16-36. MONITORING AND TRIGGER VALUES

This concern responds to the following SEARs for SSD 5765:

Figure 4.6
GROUNDWATER MONITORING
NETWORK AND WATER LEVELS

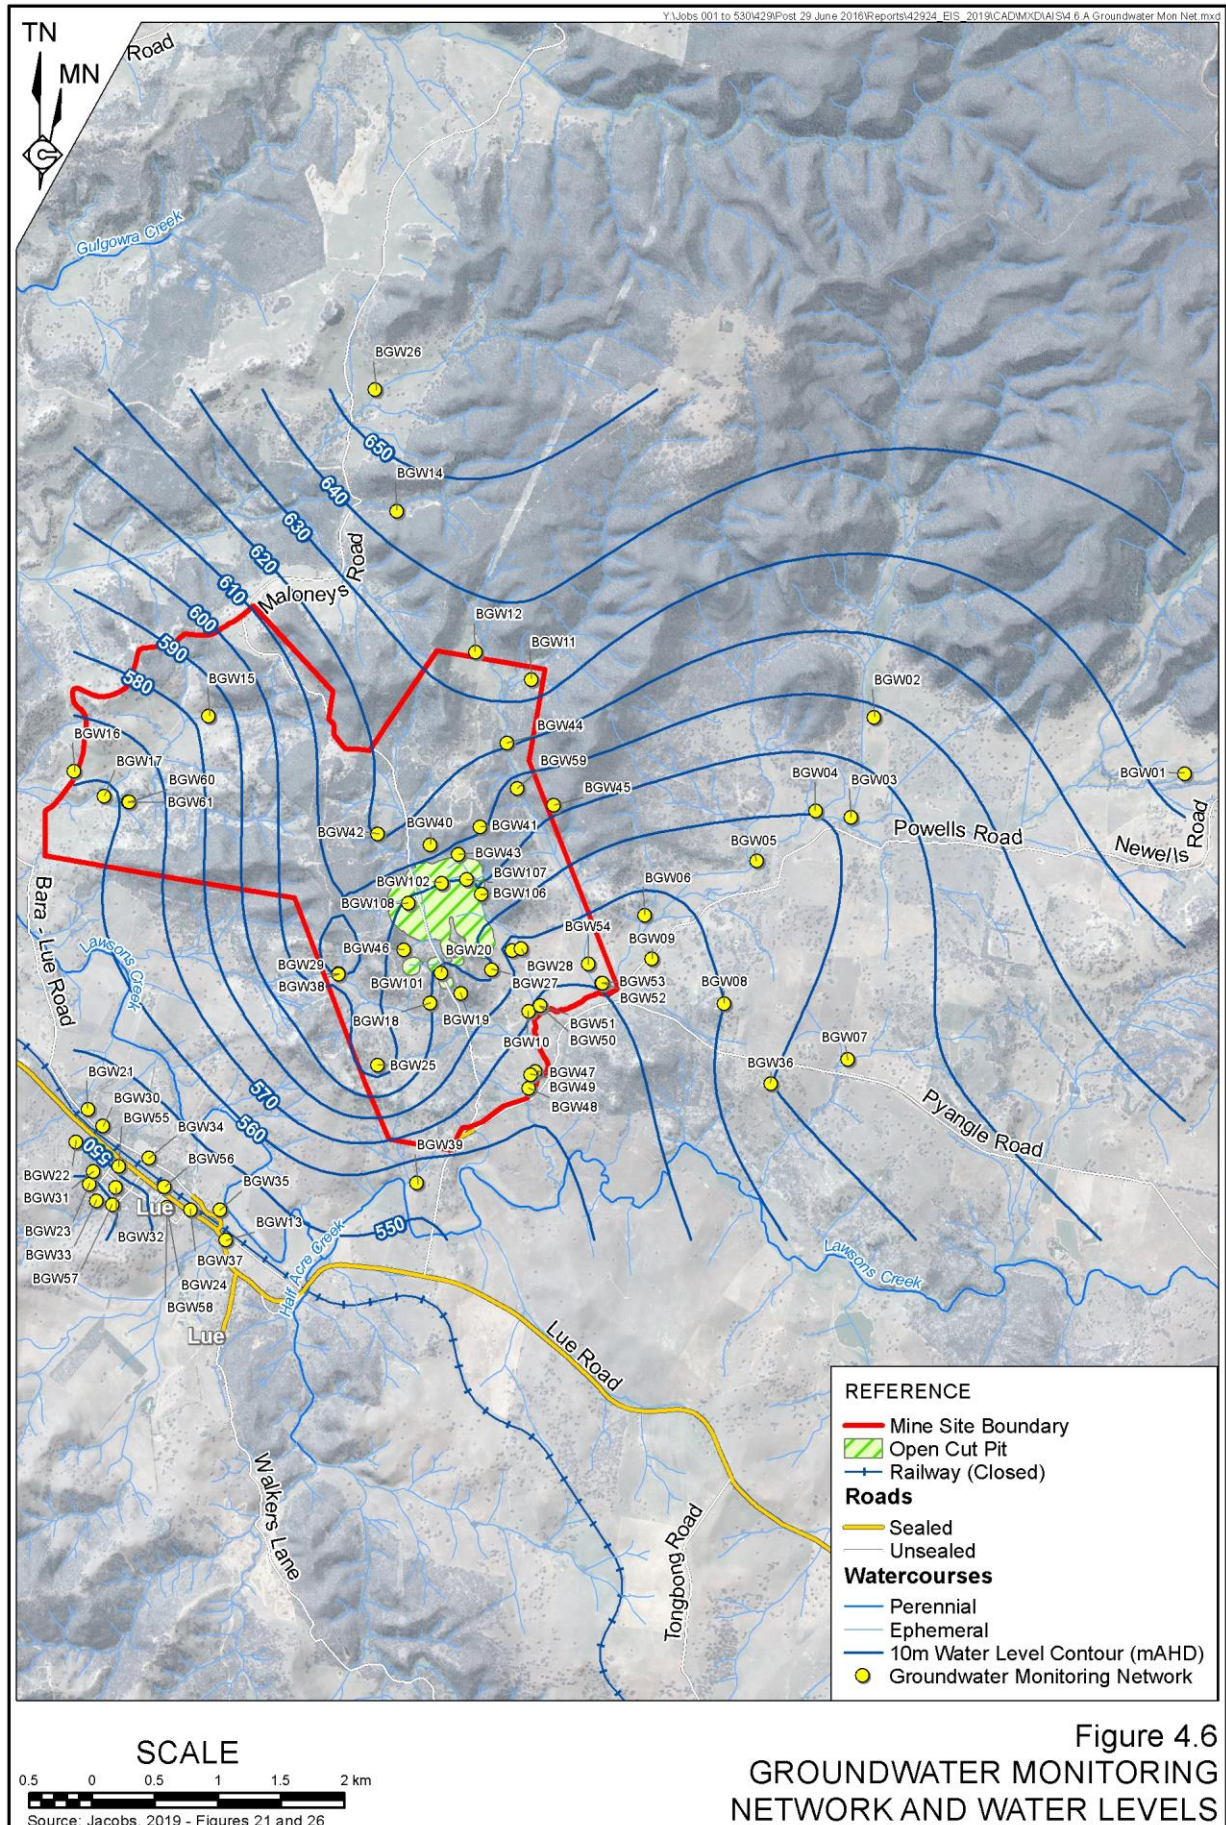
A Water Management Strategy and details of a Trigger Action Response Plan are required in the SEARs. Impacts to significant water resources and threatened species must be minimised to the greatest extent practicable. There is no inference of where new monitoring wells will be drilled, nor which locations will be used to monitor what during and post mining. Identifying the dependence of groundwater users, including ecosystems, on the native groundwater system would enable an effective monitoring plan, including trigger levels against analytes or water levels (availability), to be determined.

The risk to water quality, especially from contaminated groundwater bypassing seepage collection ponds, has not been modelled in the EIS. The proposed location and number of seepage collection ponds has not been stated.

Water of non-potable salinity from the pit lake is free to enter the aquifer once the pit water level equalises after mining, however, neither salinity monitoring around the lakes nor trigger levels and remedial actions have been specified. Due to the potential for evolution of sulfuric acid from waste rock and tailings which can liberate heavy metals from minerals in contact with groundwater, clear trigger levels and comprehensive monitoring is required to validate the predictions made in the impact assessment and to ensure that the rights of existing users are protected.

Developing a framework for a risk assessment would enable objectives to be agreed and trigger levels to be set. A Trigger Action Response Plan can then identify actions that would be taken to remediate exceedances.
